V3 RESPONSE from GWEPC to CDC Planning (Jun 24) RE OUFC Stadium Environmental Statement dated Feb 2024

Gosford and Water Eaton Parish Council (GWEPC), following consultation with parishioners, objects to the planning application for the Oxford United Football Club (OUFC) Stadium. Whilst the design of the stadium appears to be to a suitable standard, it is the impact on the surrounding area which is our primary concern. Although the stadium itself is not located in our parish, it does however have a major impact on our community. GWEPC objects on the following basis with references to the Environmental Statement dated February 2024:

FIGURE 7.46 ARBORICULTURAL IMPACT ASSESSMENT PLAN (PART 1)

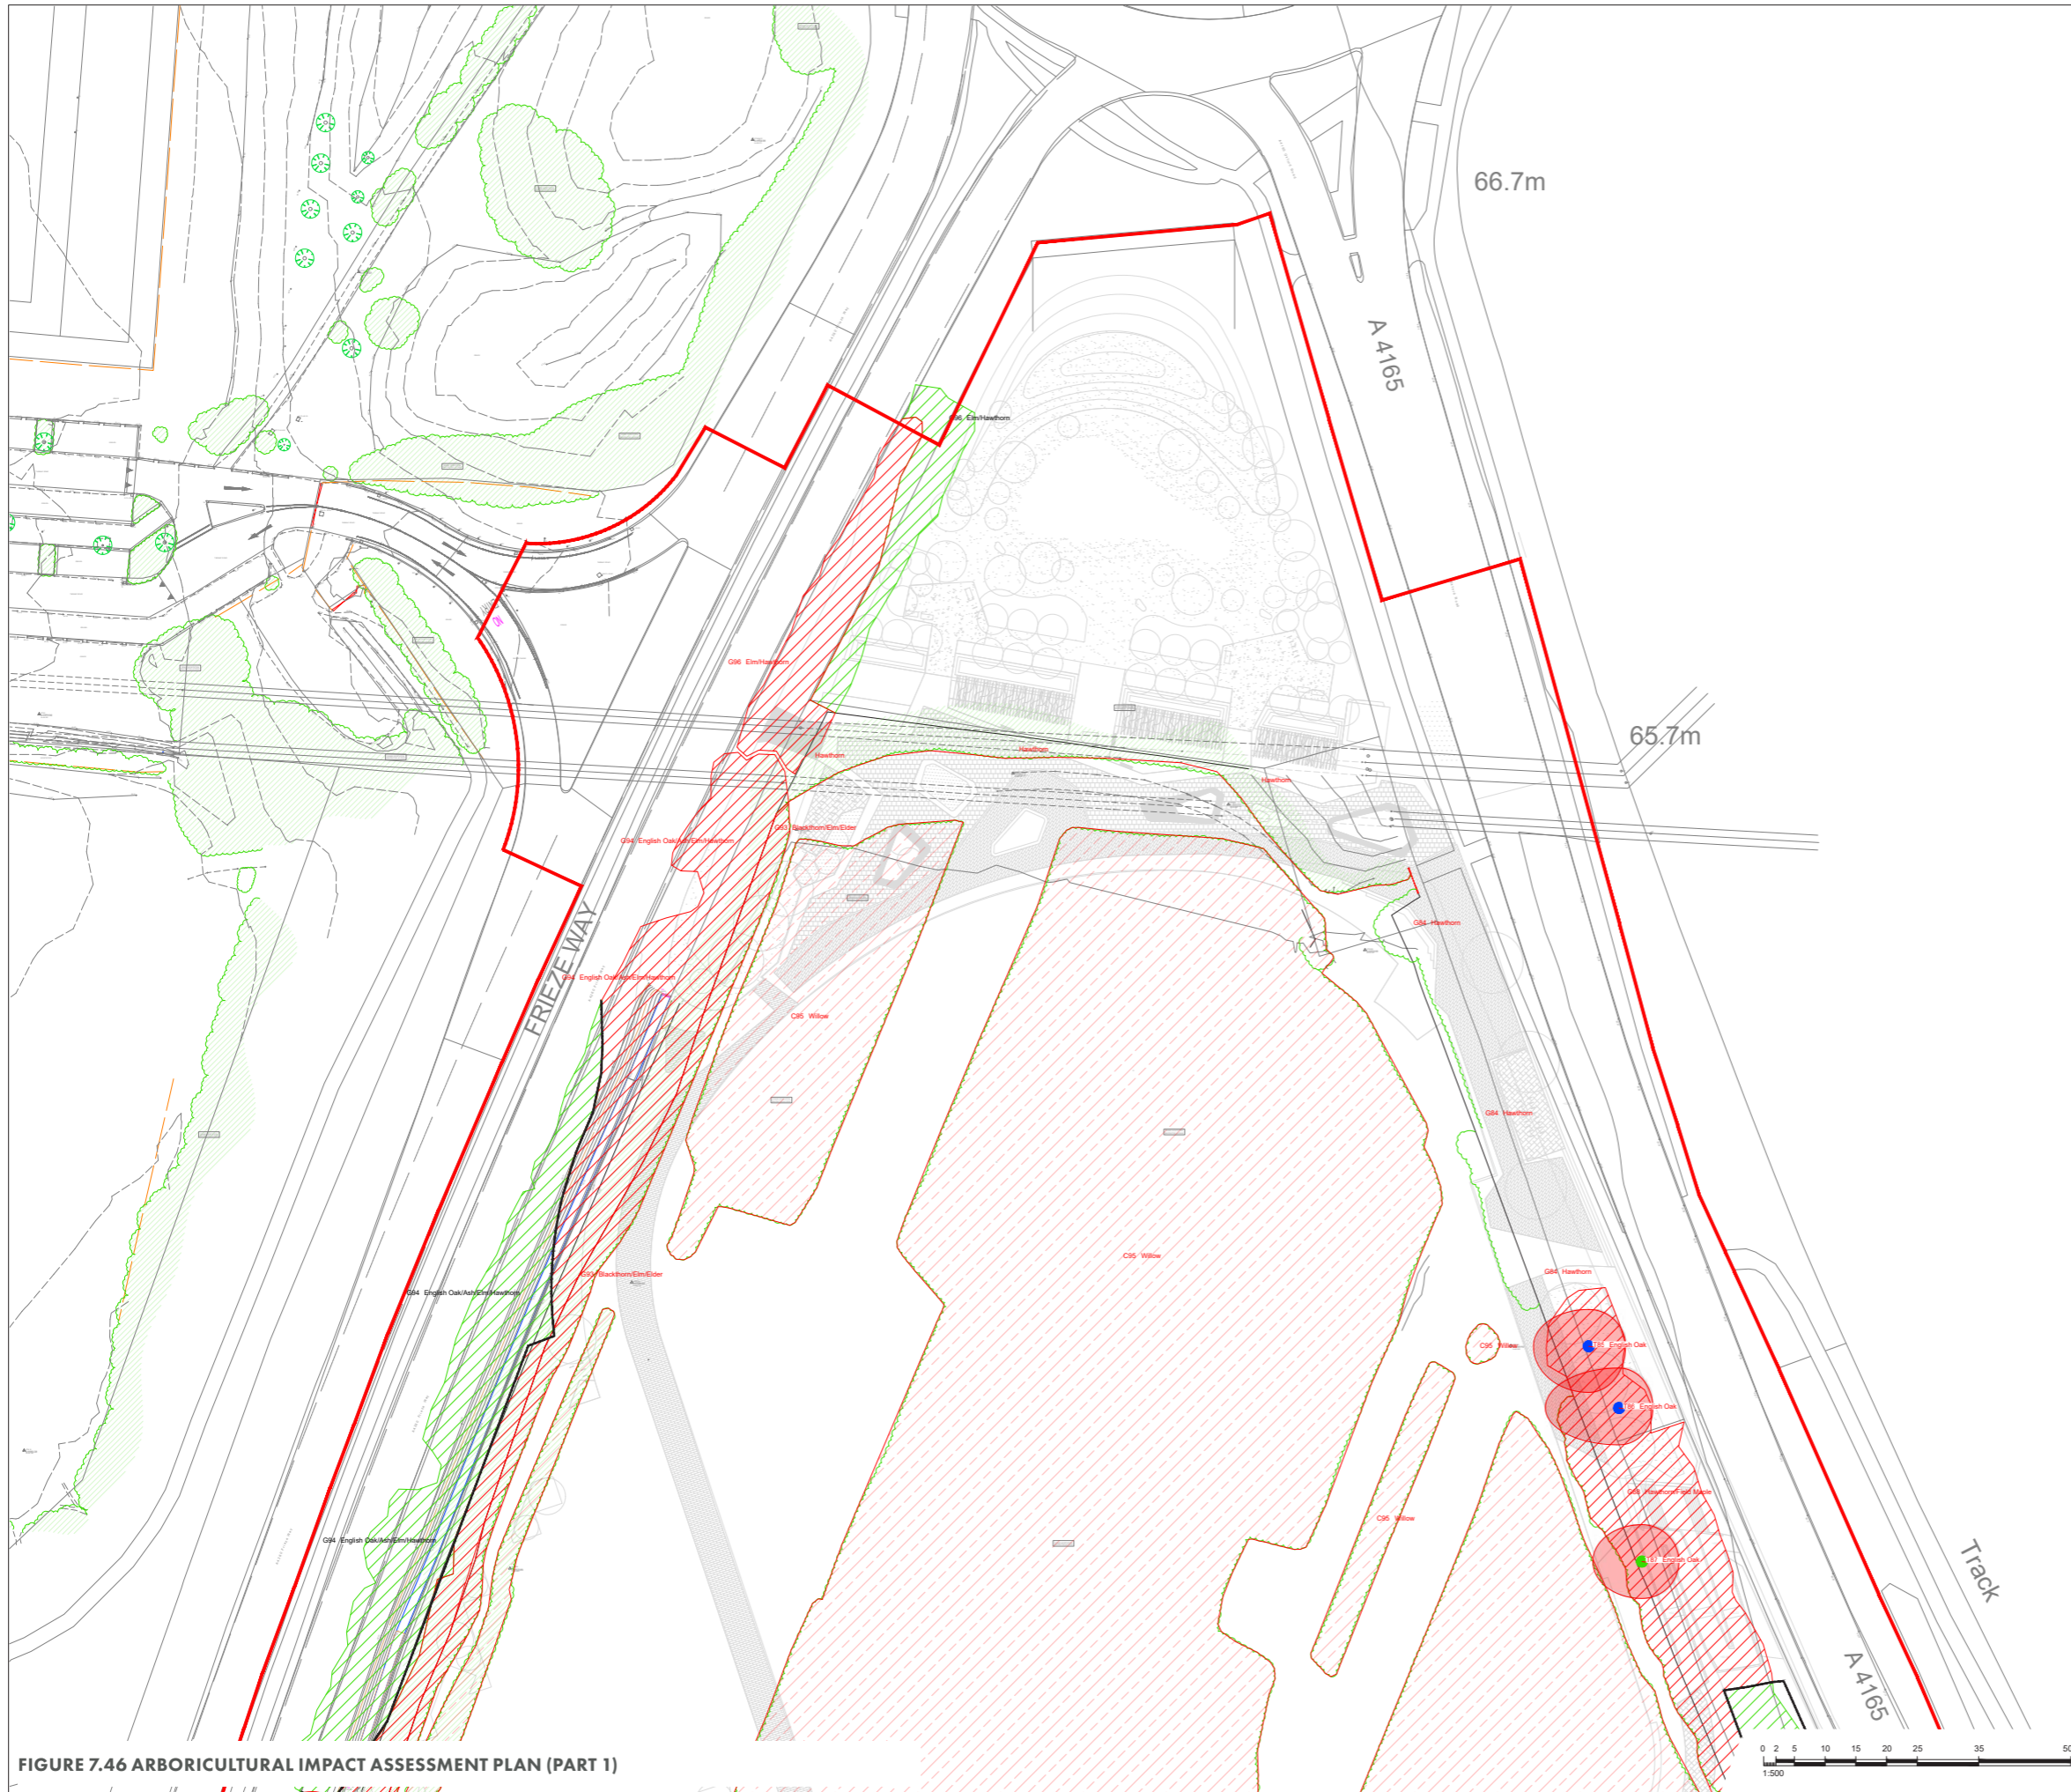
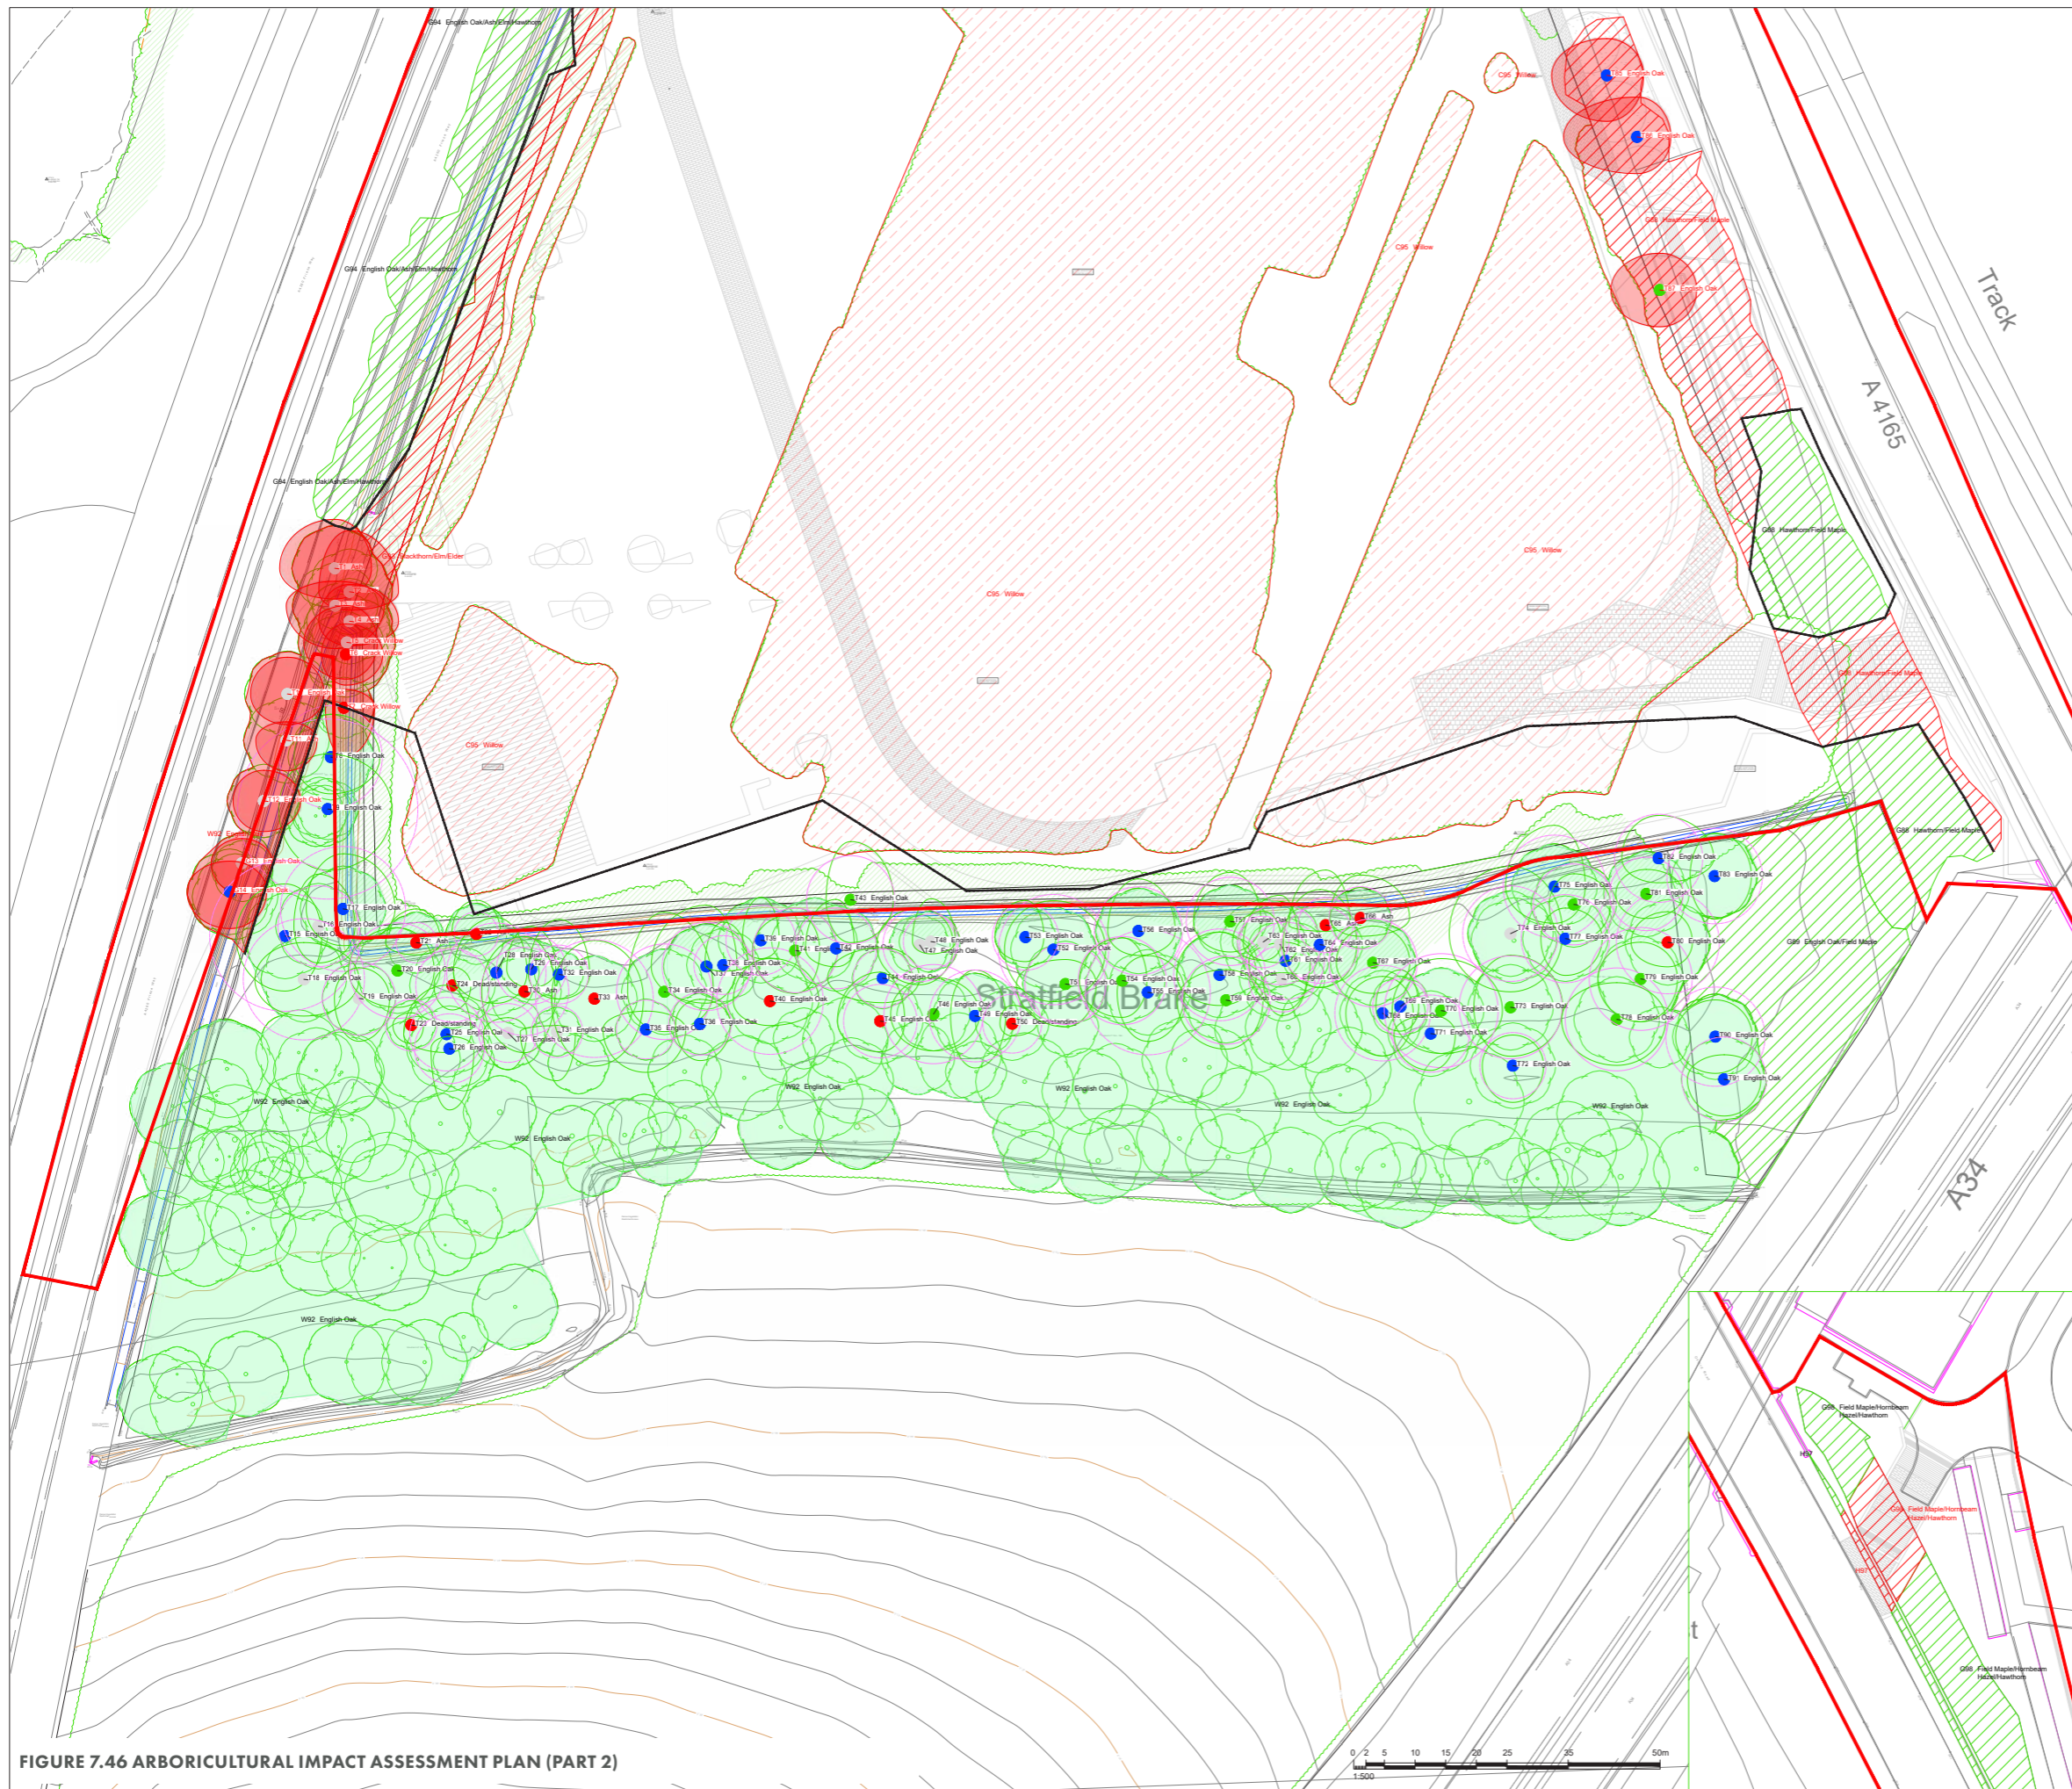
There is concern expressed by GWEPC about the preservation of trees on the site. While the large poplars on the north side are protected with no plans to impact, there are 17 trees proposed to be removed even with numerous "replacement trees" to be planted a mature oak (Category A) and the Category B trees will a significant loss to the site:

Arborial Impact Statement **17 trees to be removed** (1 Category A, four Category B, 10 Category C and 2 Category U) see Figure 7.45 for detail.

GWEPC would like assurances that the biodiversity is enhanced and as many mature trees retained as possible. As well as additional planting of trees on site to compensate for the removal of trees on site. Any new trees planted must be maintained by OUFC until they are mature which is a minimum of 10 years.
